Application number: 2021/93621	
What is the application for?:	Erection of 12 dwellings and associated works (Within a Conservation Area)
Address of the site or building:	Land off, Fullwood Drive, Golcar, Huddersfield, HD7 4JH
Postcode:

Type of comment: An objection	
Do you wish your comments to be published on the website anonymously?	Yes
<p>The outline application (2017/60/93638/W) was for 10 residential dwellings and not 12 as on the latest proposals this is not acceptable. Also most of the consultation documents are based on the original proposal and thus not valid in relation to updated plans.</p> <p>Parking & Access Access via Hillcrest where existing infrastructure has already been placed would be more suitable as recommended by Kirklees Highways & for the following reasons:</p> <ol style="list-style-type: none">1. Clay Well/Small Lane operate as one lane in parts, more traffic is not acceptable. This is also applicable on Fullwood Drive where on street parking is fundamental to the residents but also would restrict access.2. As you go down Victoria Lane it is cobbled which is a fundamental character material Golcar but not suitable for more vehicle traffic.3. The Land owned

Appendix 2. Proposed Habitats

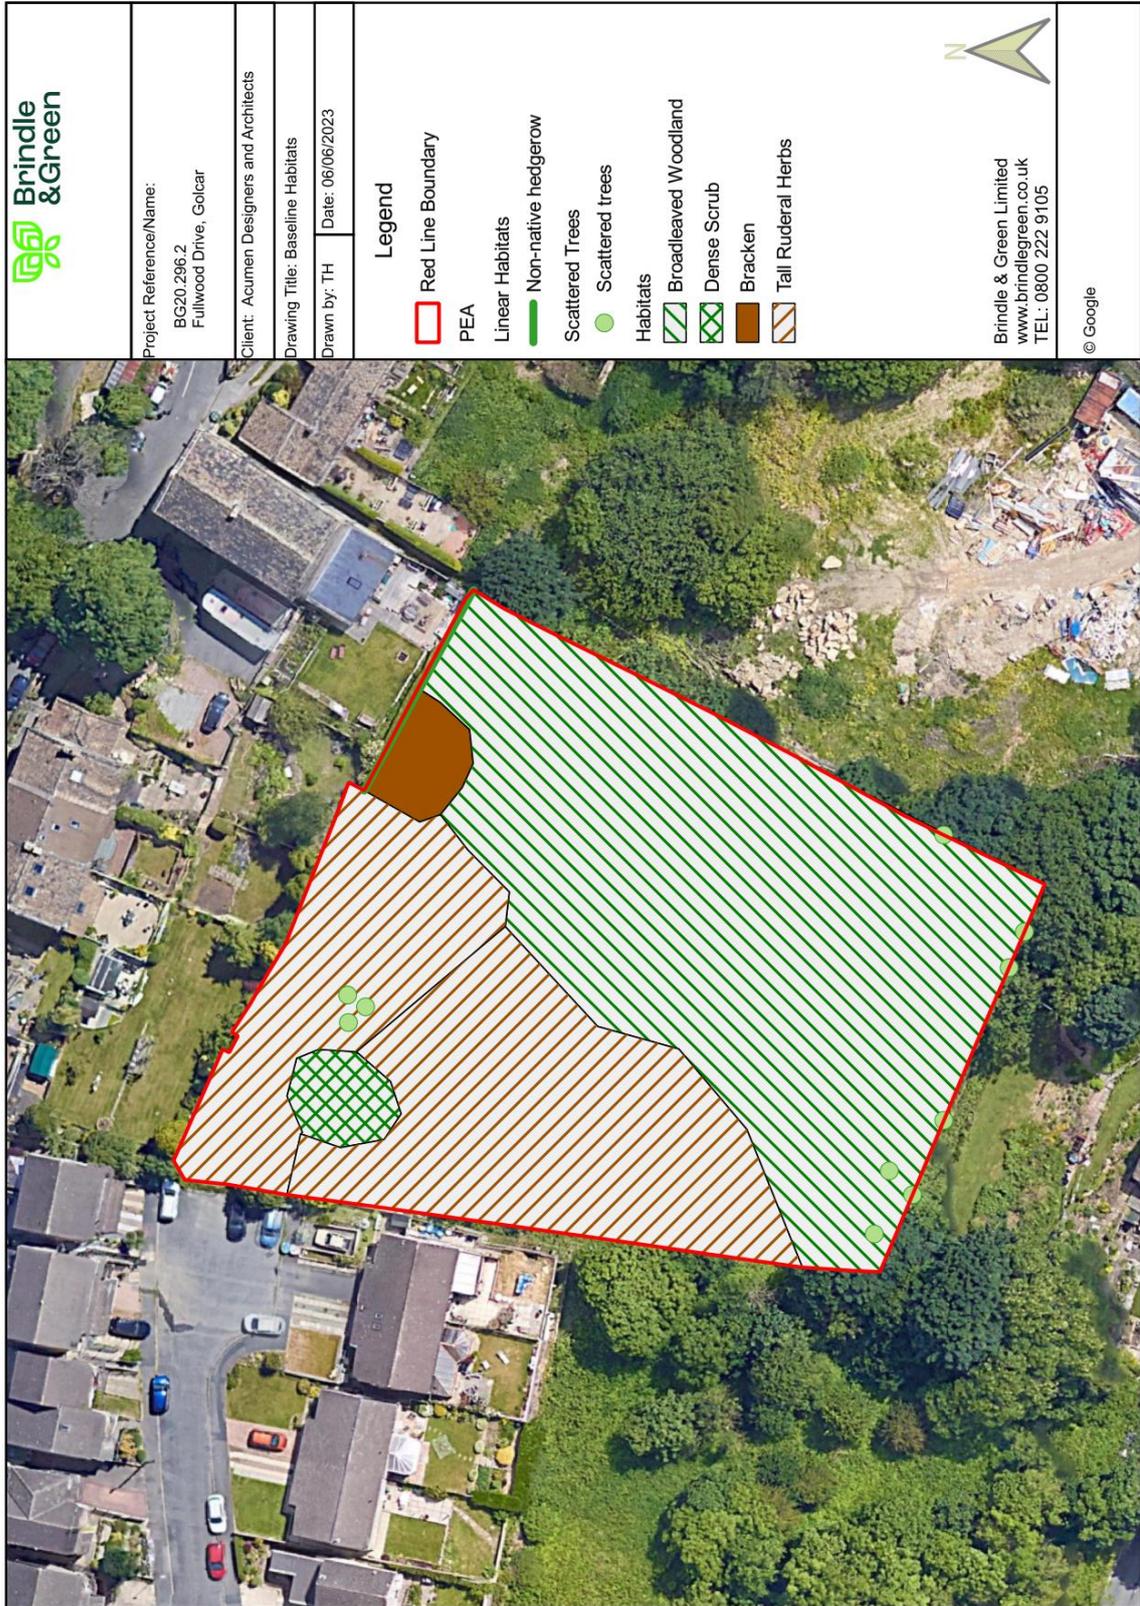
1. No new trees as recommended by Kirklees are shown on the most recent proposals and the applicant has answered 'No' to the question 'Are there trees or hedges on the proposed development site:' on the application form. However 11 new street trees are shown on the old plan in the latest BIA?
